**Re: Major Project MP09_0154
Project Application for a mixed use commercial residential building at
7 Railway Street, Chatswood**

SUBMISSION TO DEPARTMENT OF PLANNING ON MPO9_0154 FOR A PROPOSED MIXED USE RESIDENTIAL COMMERCIAL BUILDING AT 7 RAILWAY STREET CHATSWOOD

Copyright of the design and other information shown here is owned by Mirvac Design Pty. Ltd. Reproduction or use of the design by any party for any purpose is expressly forbidden without the written permission of Mirvac Design Pty. Ltd.

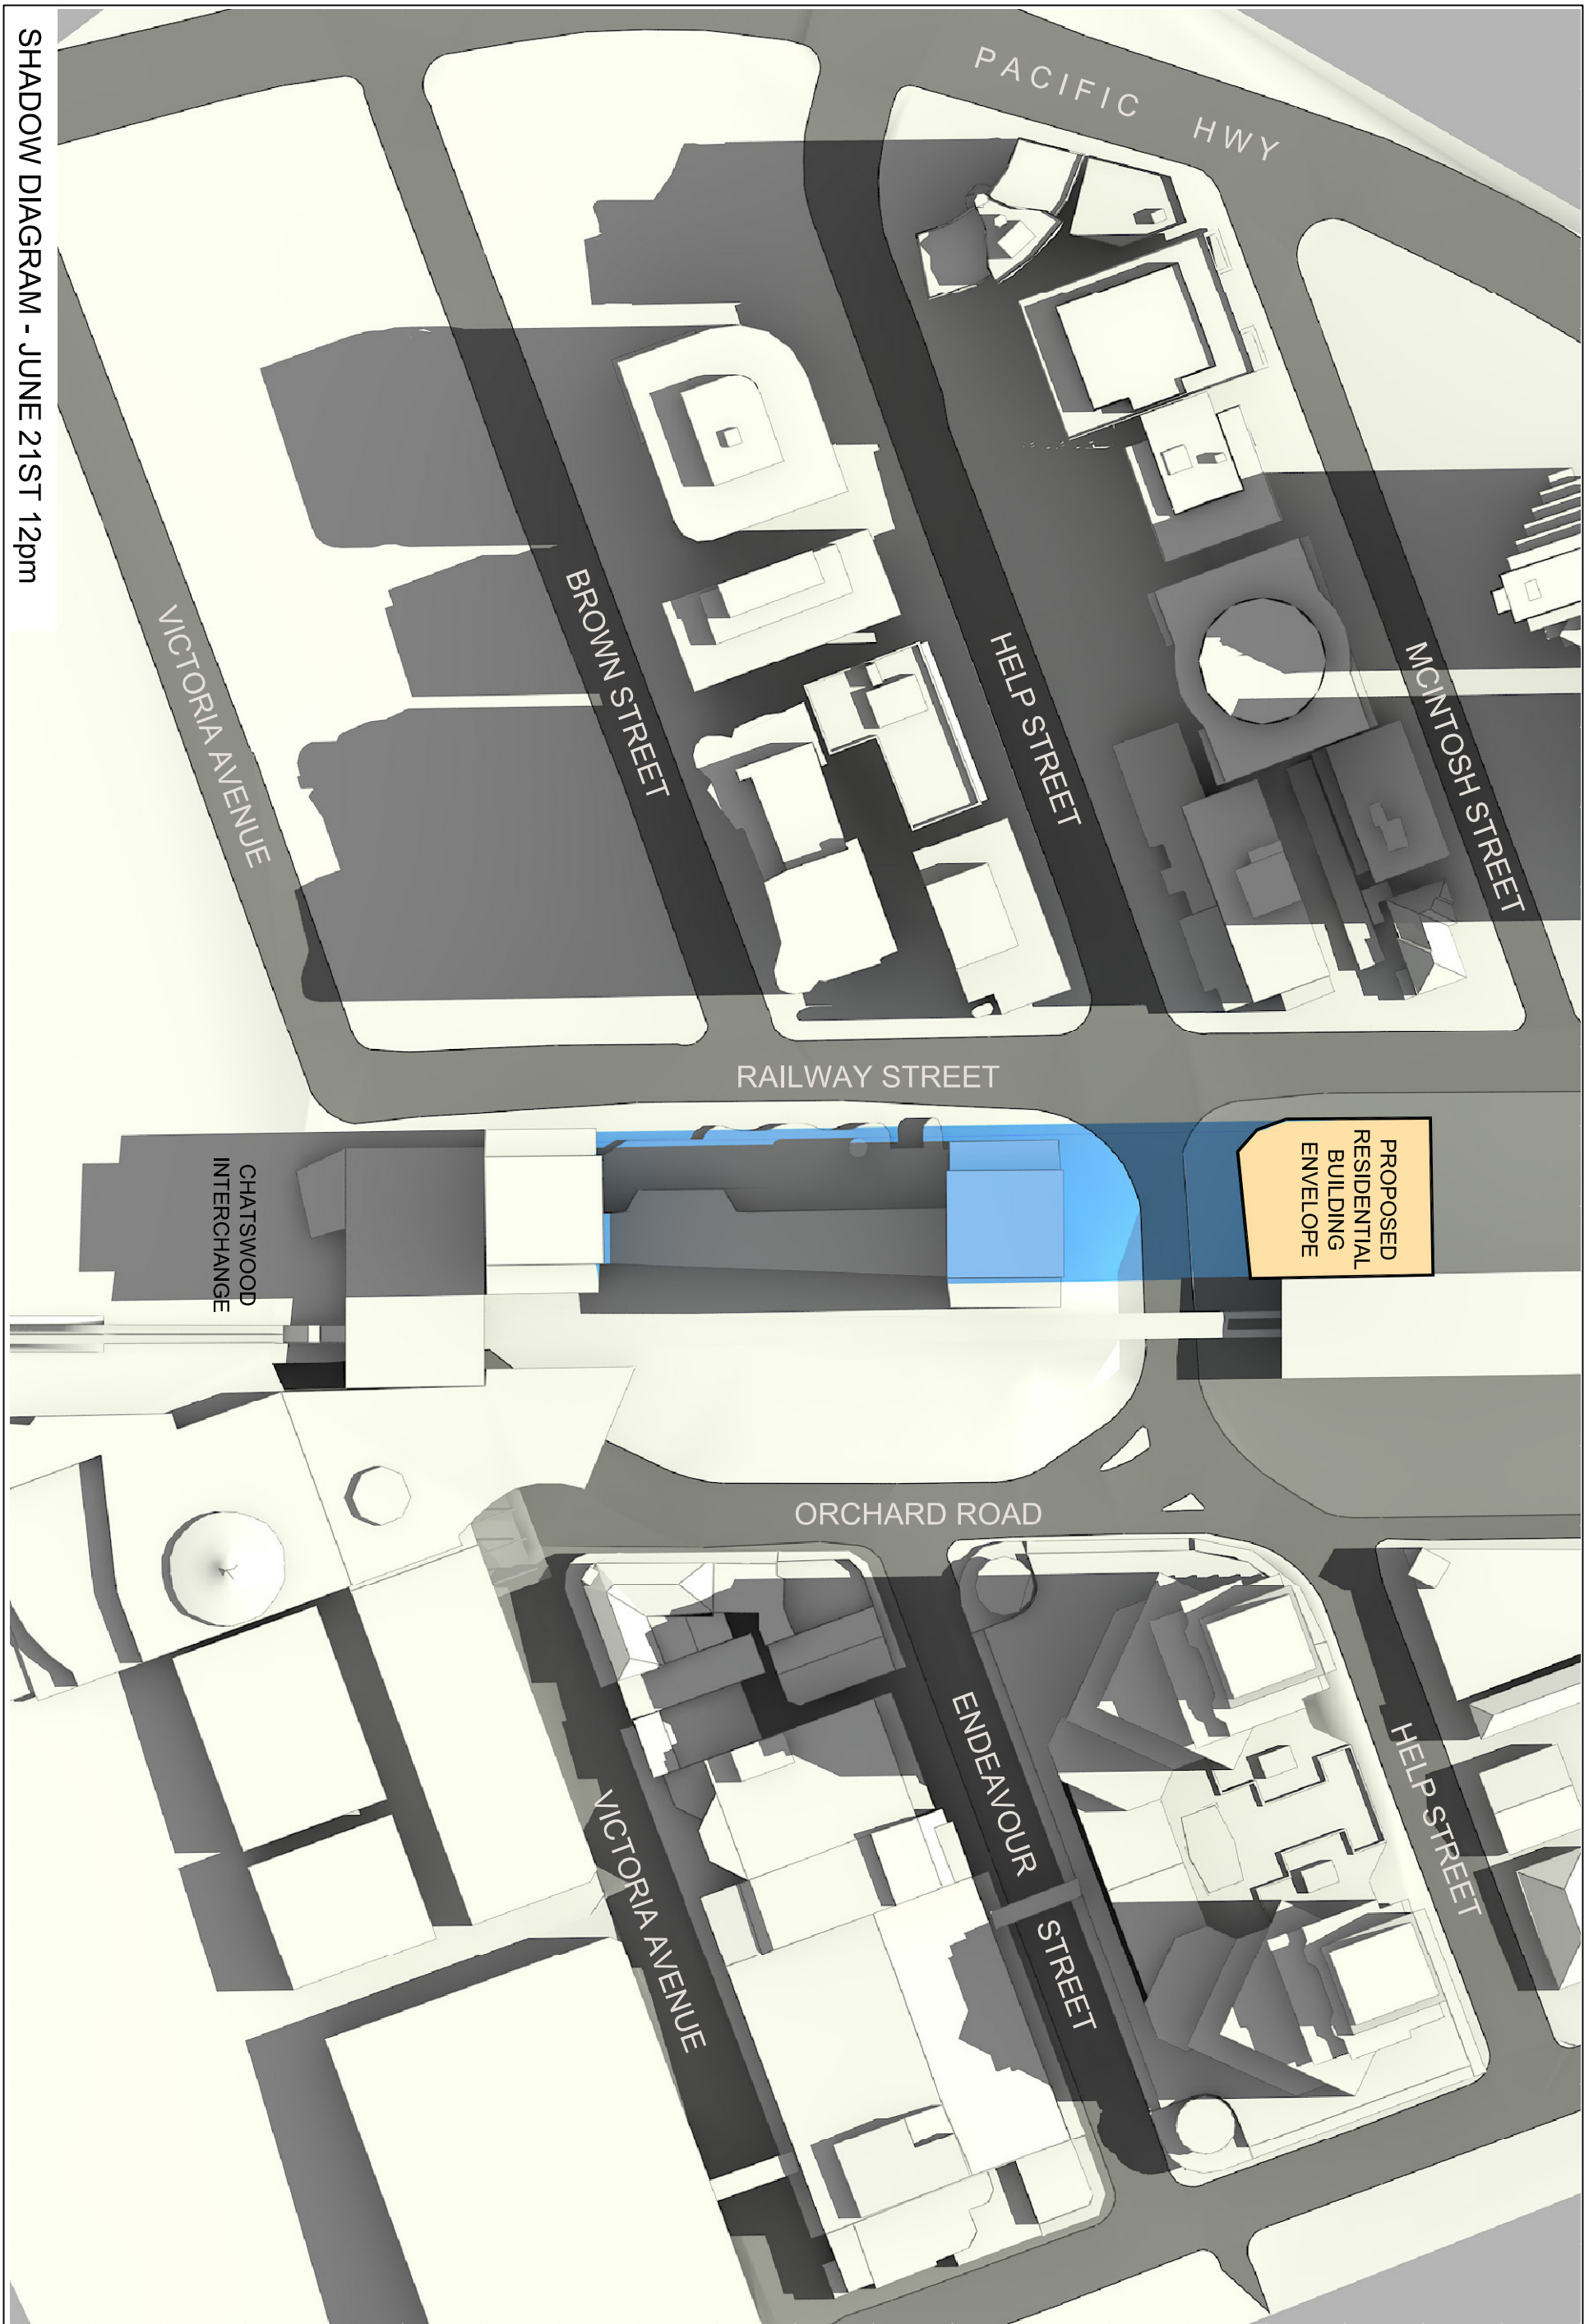
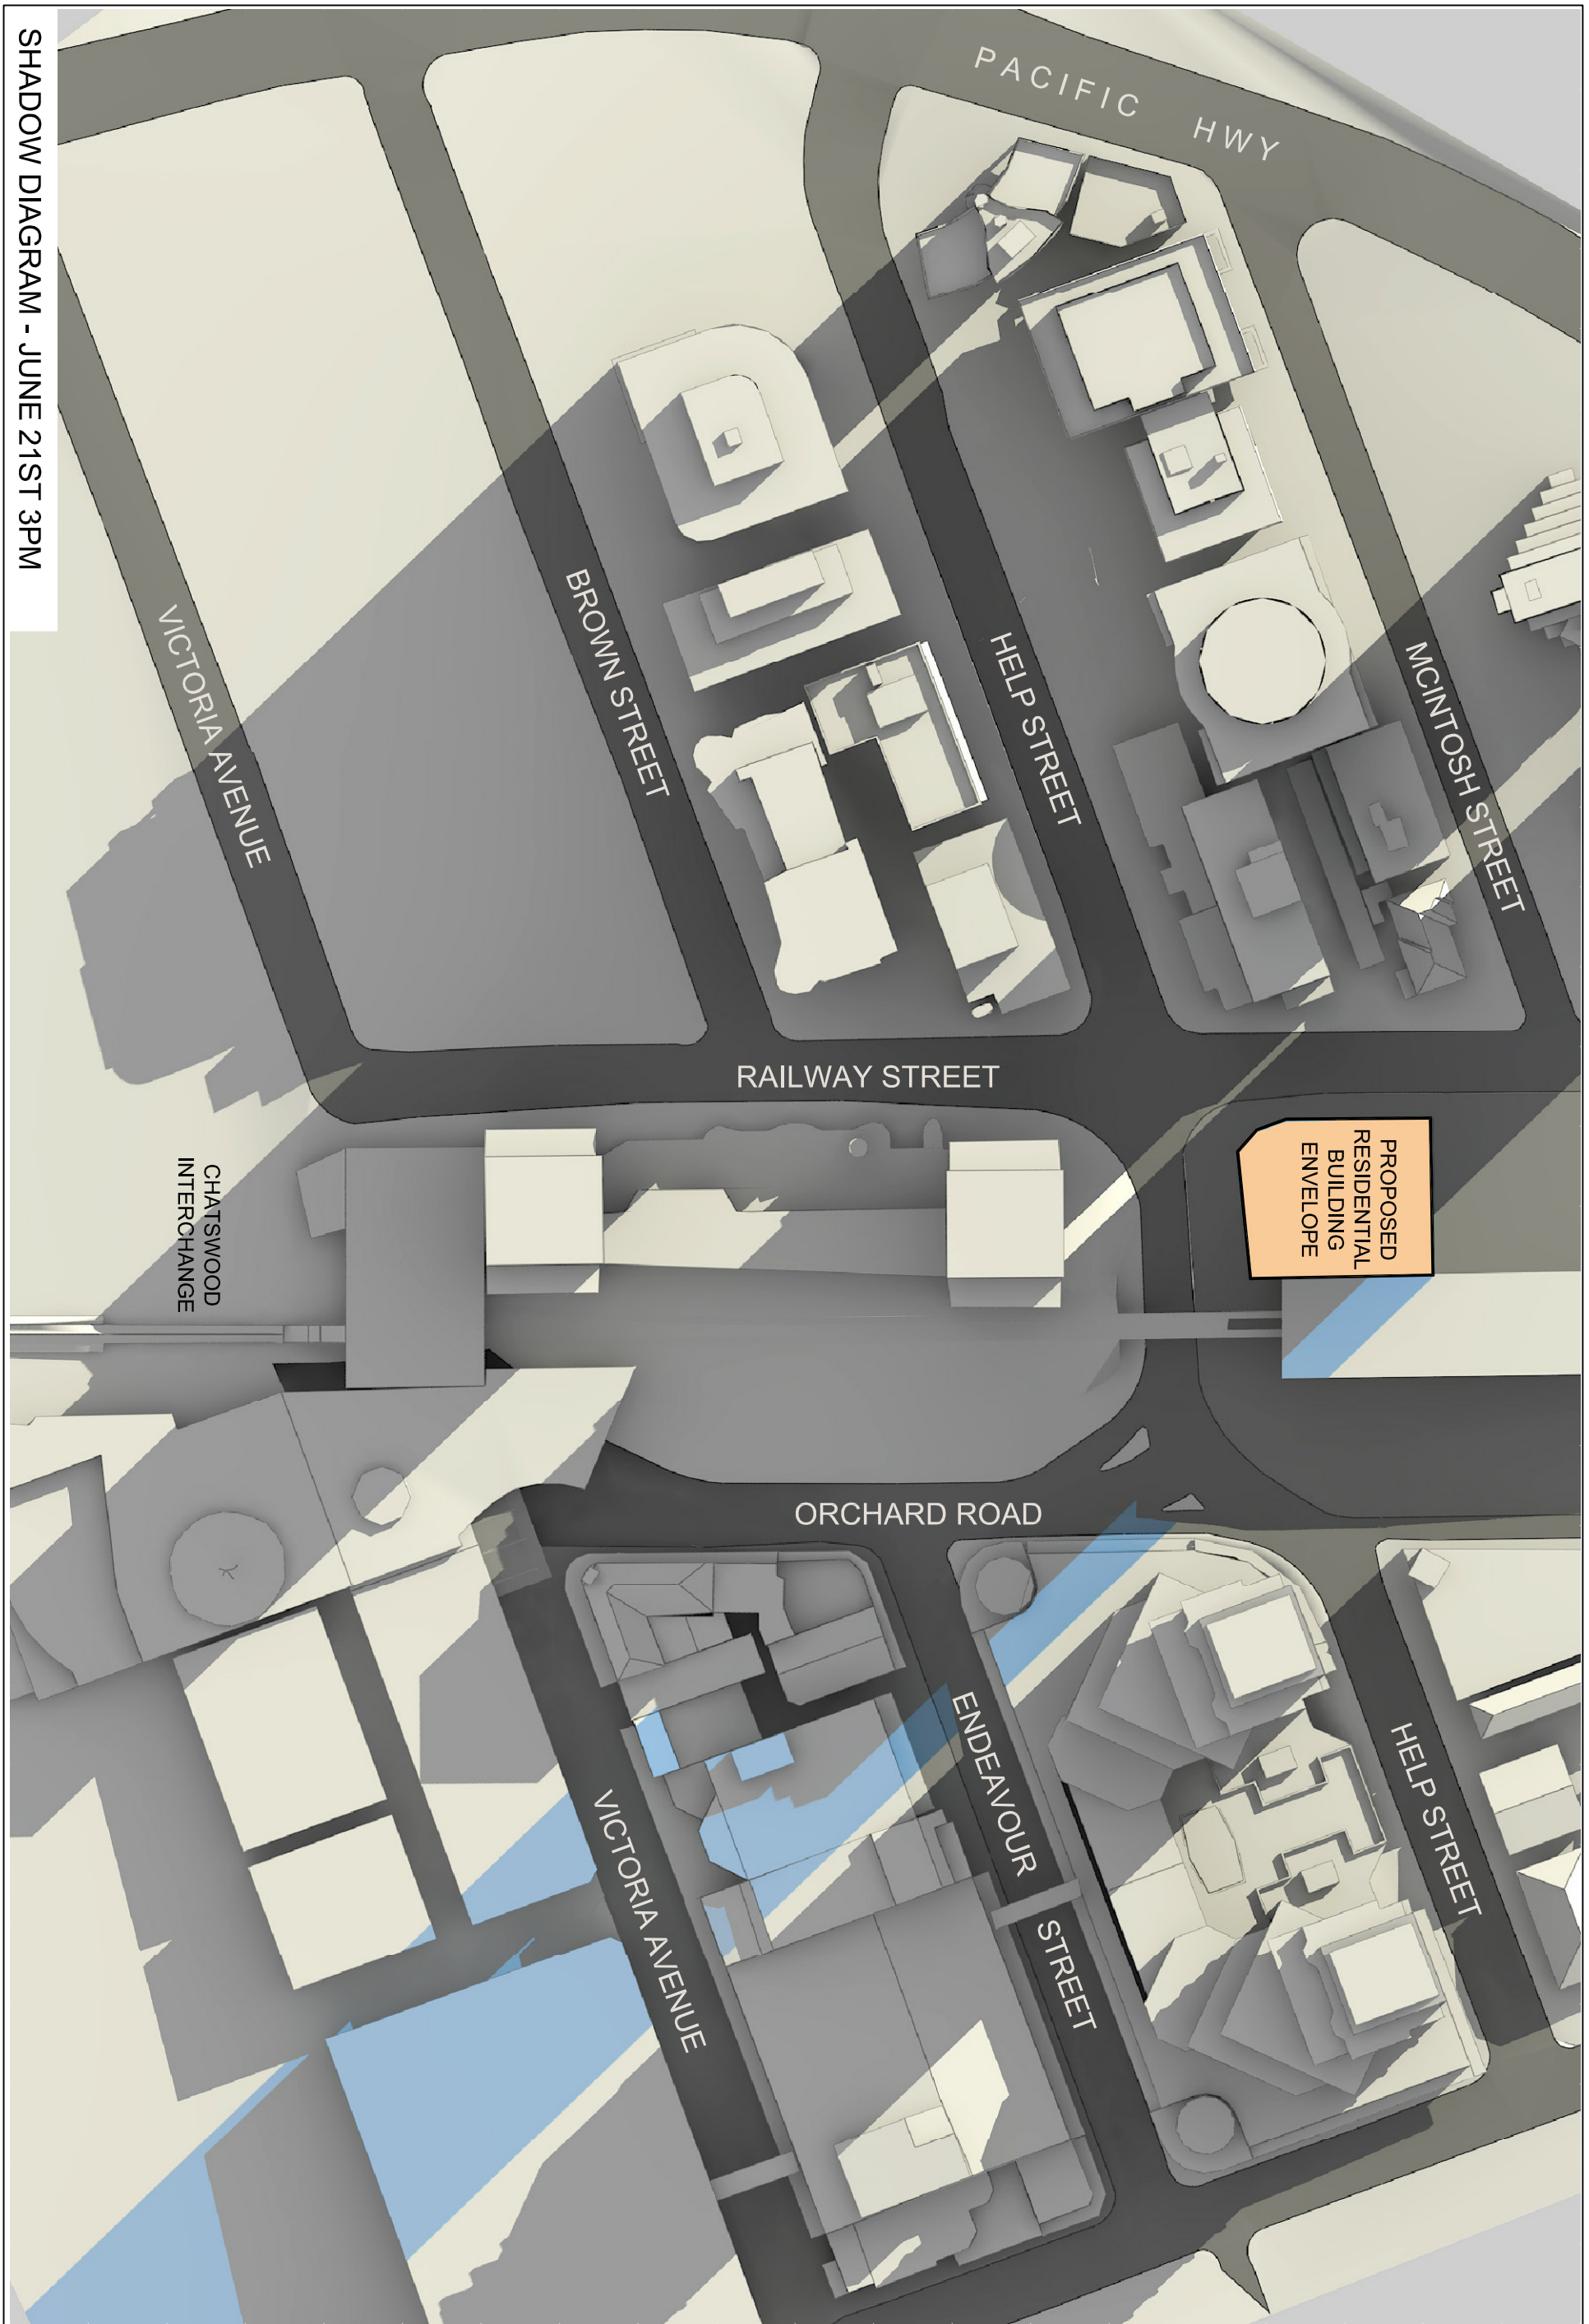
5. The application should be refused as the shadowing impacts on the public domain have not been adequately addressed and Council is concerned that the shadowing from the additional height will adversely impact the public domain of Chatswood.
